Date 20 September 2021

RE: 6/2021/0505/COND – H R Owen, Mosquito Way, Hatfield, AL10 9WN

Thank you for your consultation in relation to the above planning application for the Submission of details pursuant to conditions 1 (construction management plan), 2 (surface water drainage) and 7 (details of foundation design of approval) on planning permission 6/2019/1411/MAJ at H R Owen, Mosquito Way, Hatfield, AL10 9WN.

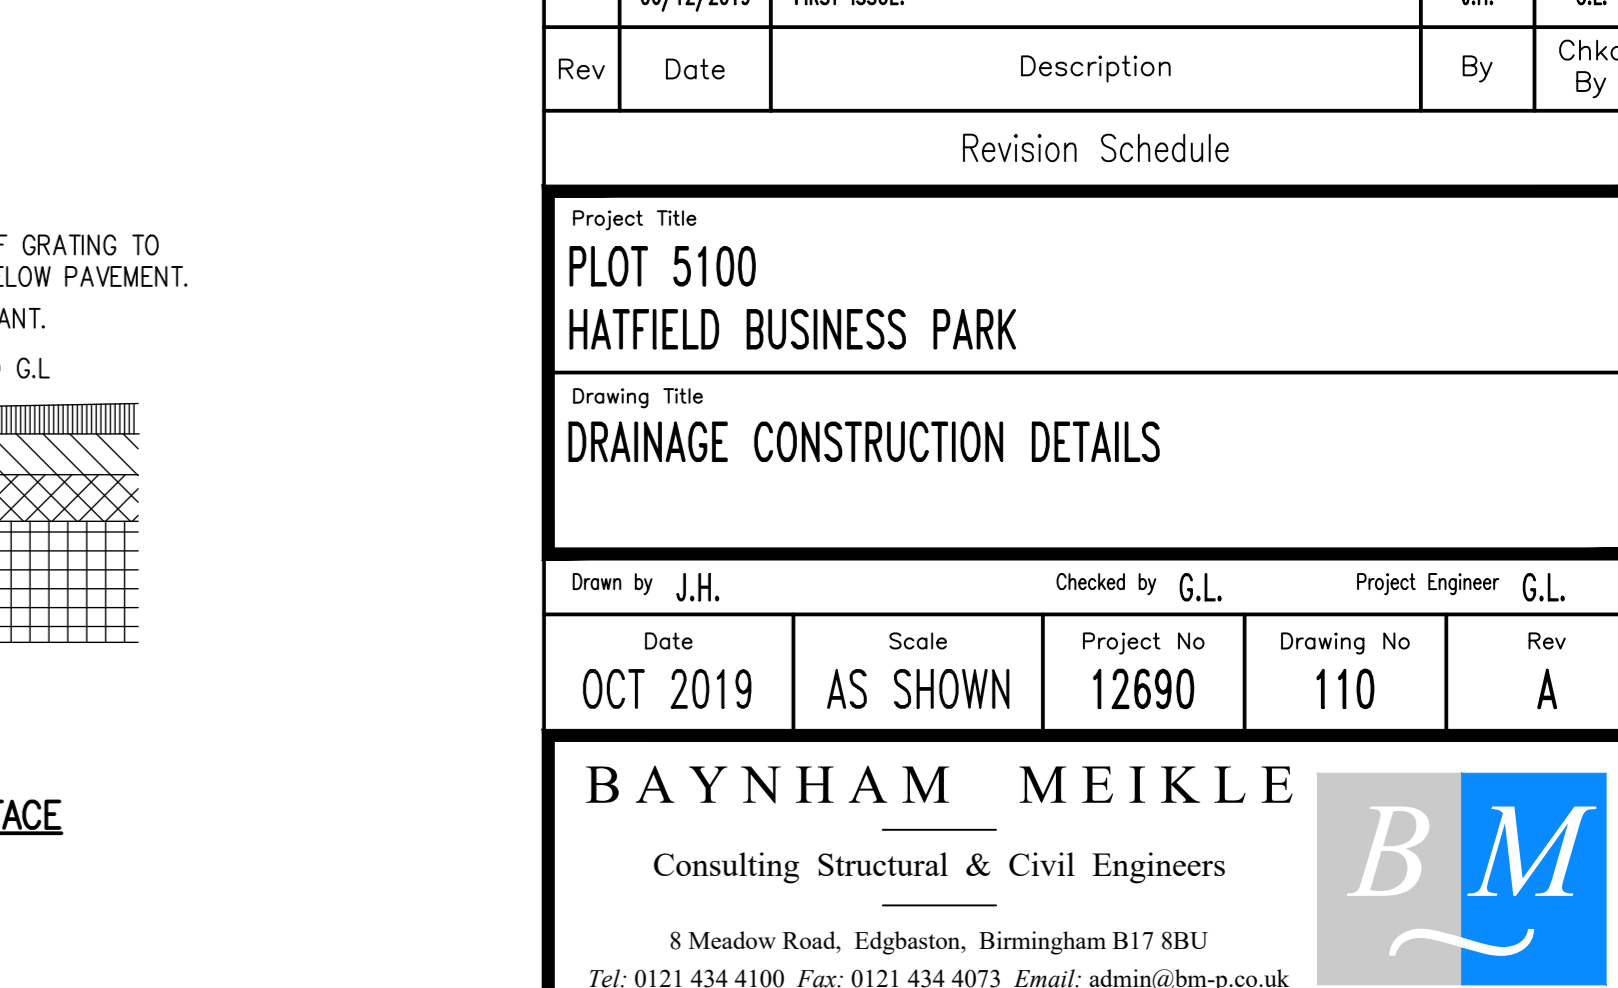
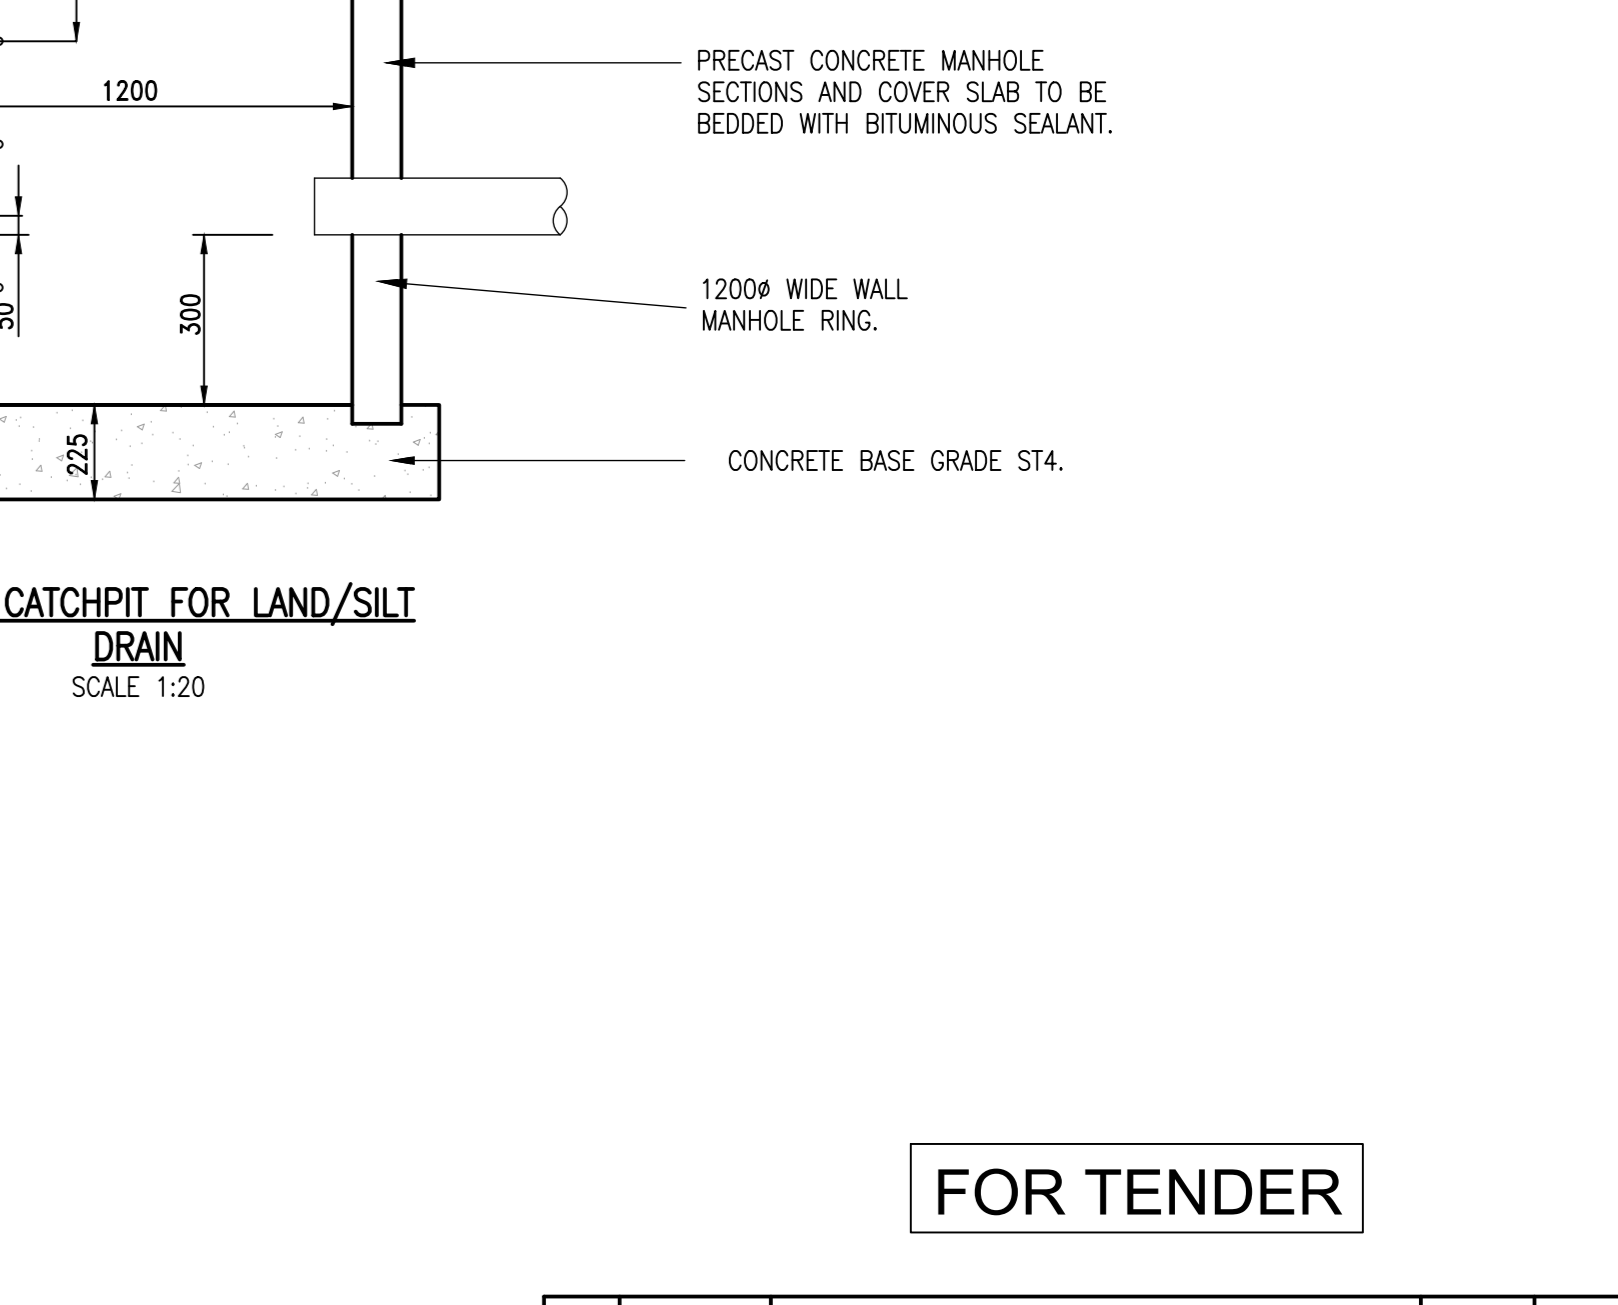
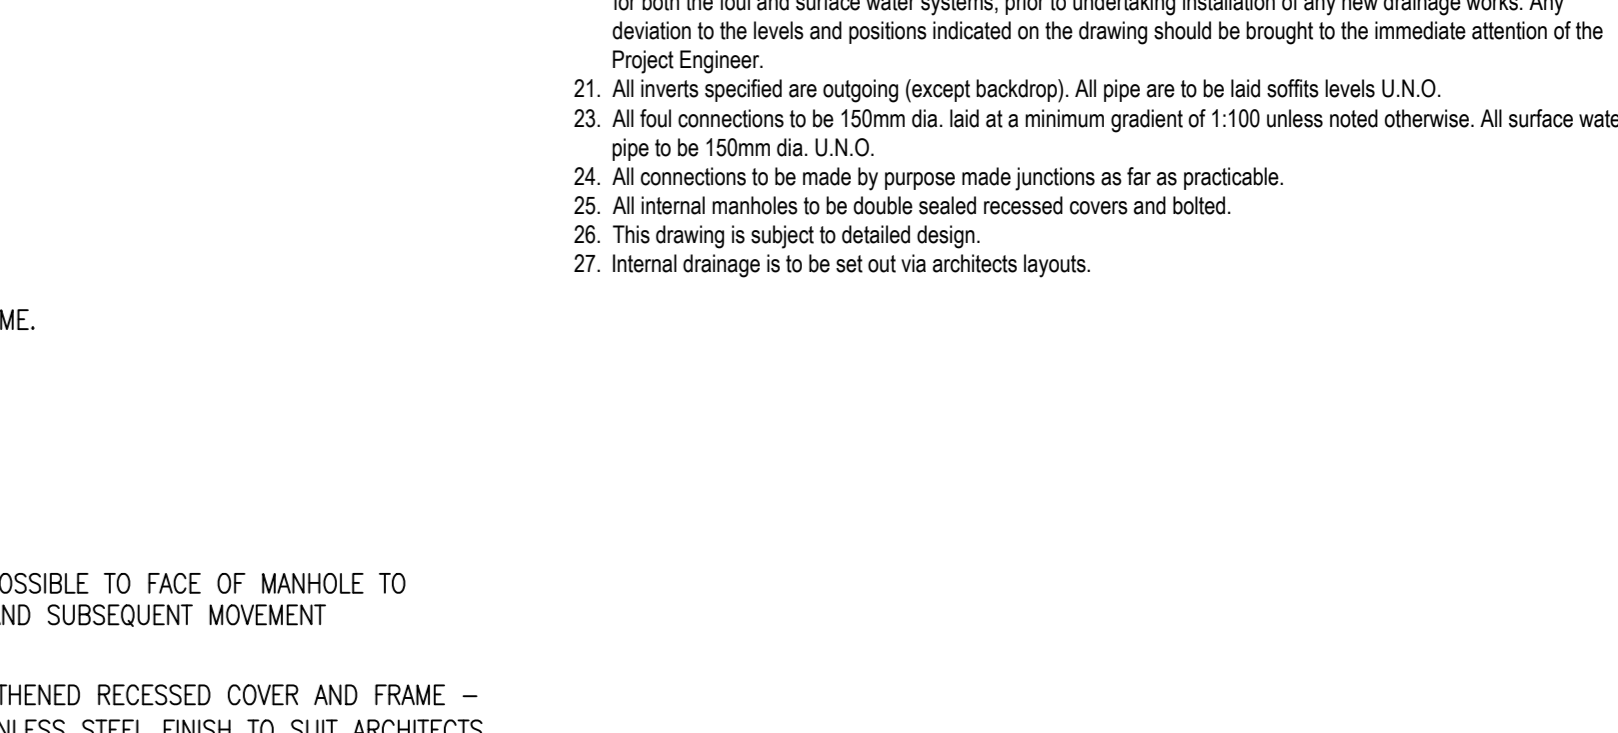
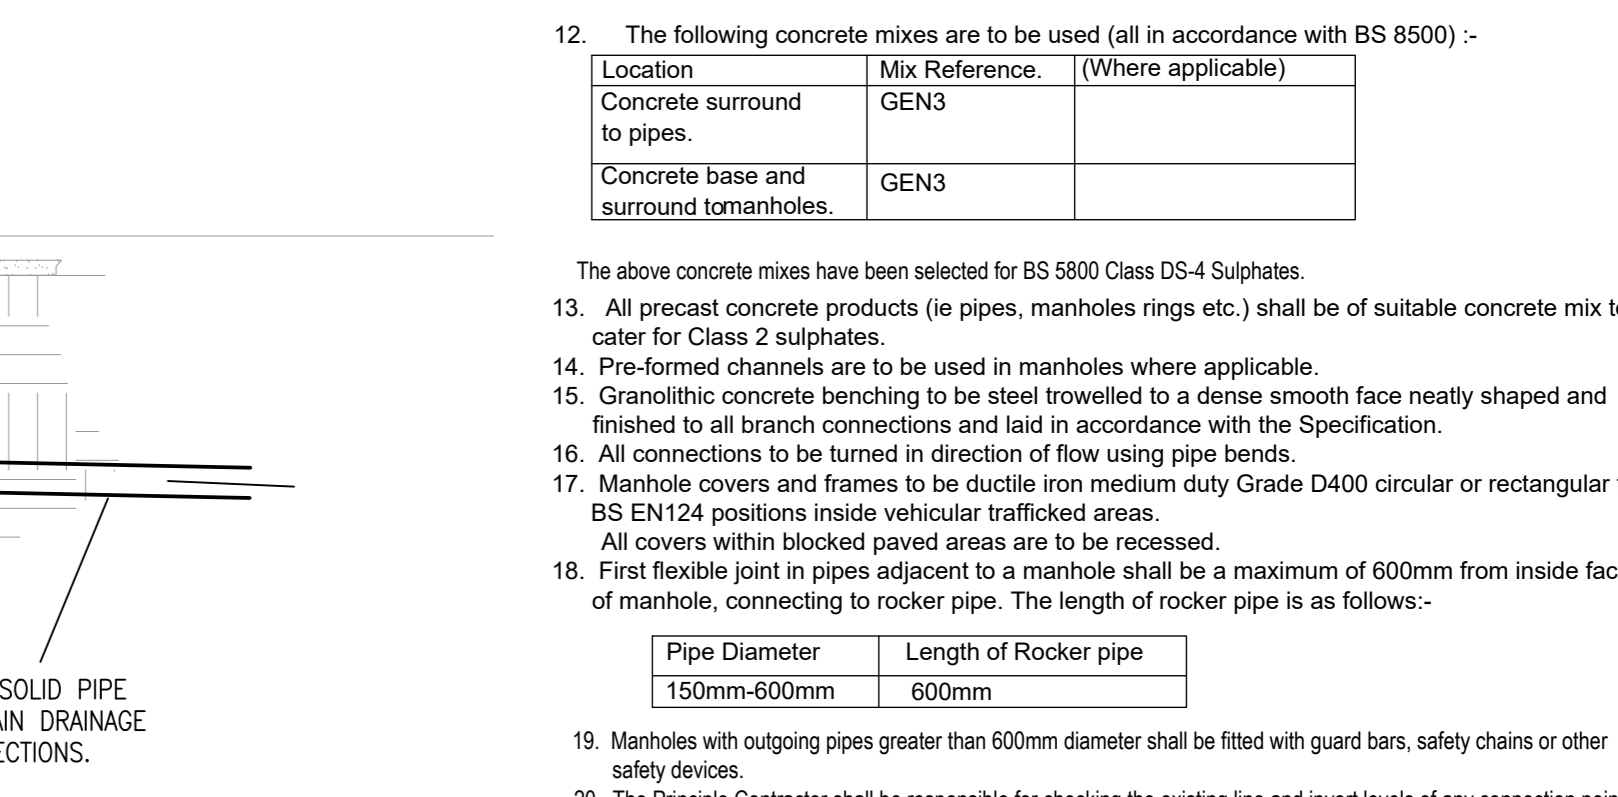
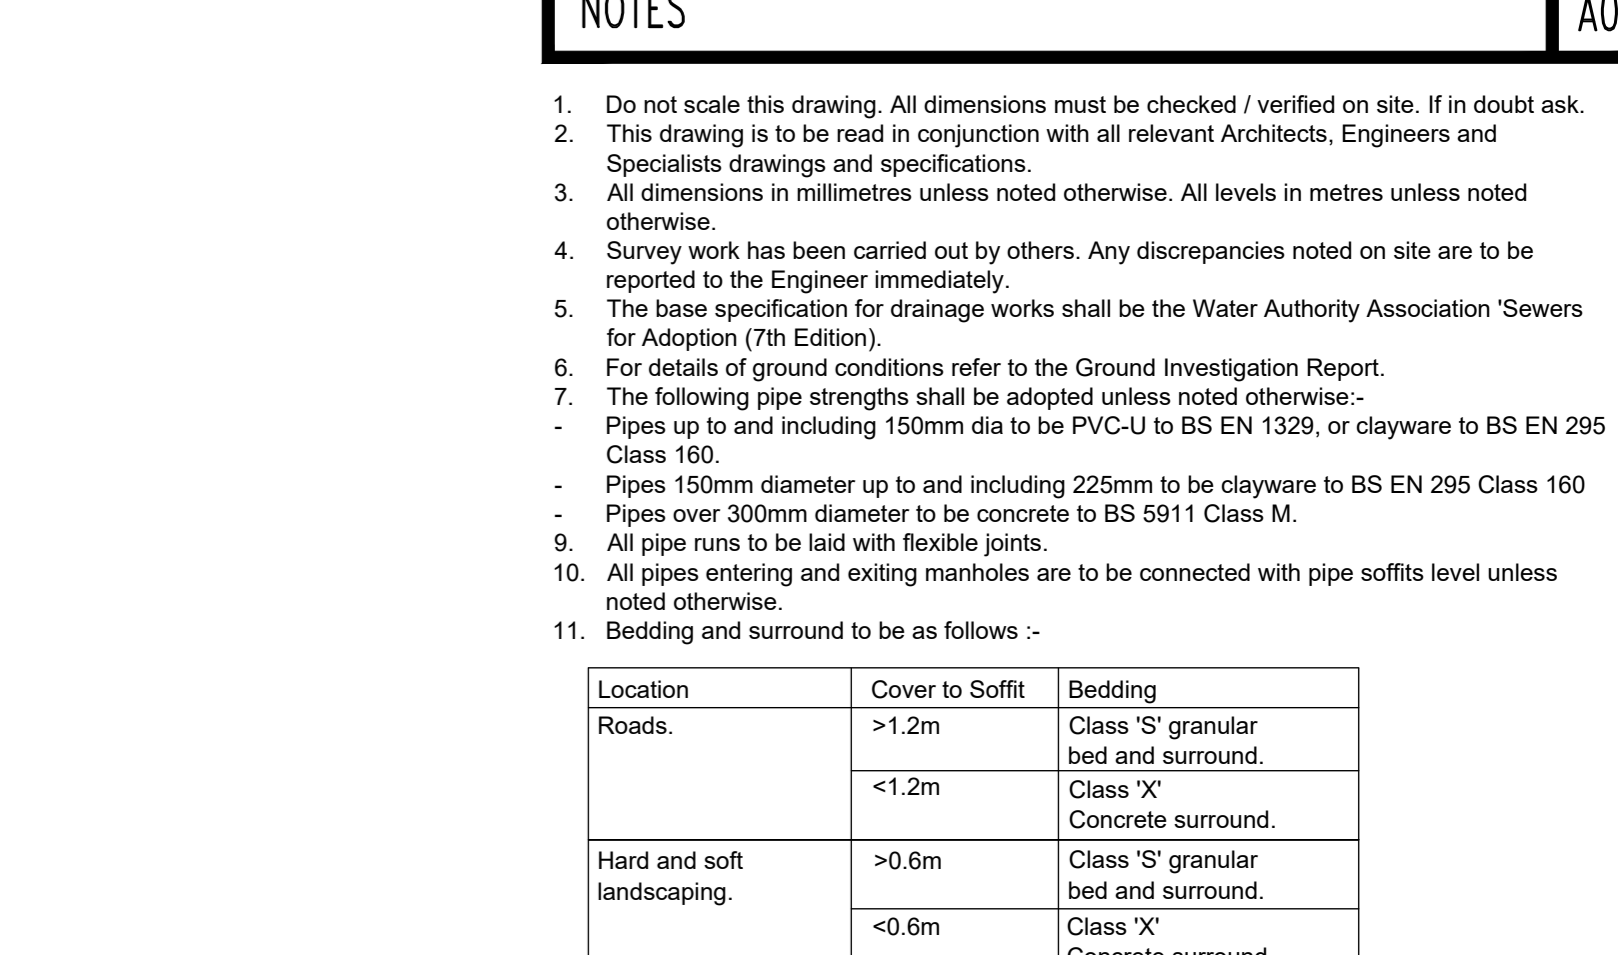
We acknowledge the applicant has provided a drainage strategy based on 122 l/s discharge, but with slightly updated network. Detailed modelling has been submitted to support the latest design.

We are pleased the applicant has now routed the gullies draining the access road to the permeable paving to provide SuDS management and treatment prior to draining to the strategic network.

The applicant has clarified that the pipe run between SMH15 and SMH17 is not under a building.

The applicant has also provided an updated SuDS Maintenance Plan including maintenance activities for the Tubosider tank.

As such, we would now recommend the discharge of condition 2.
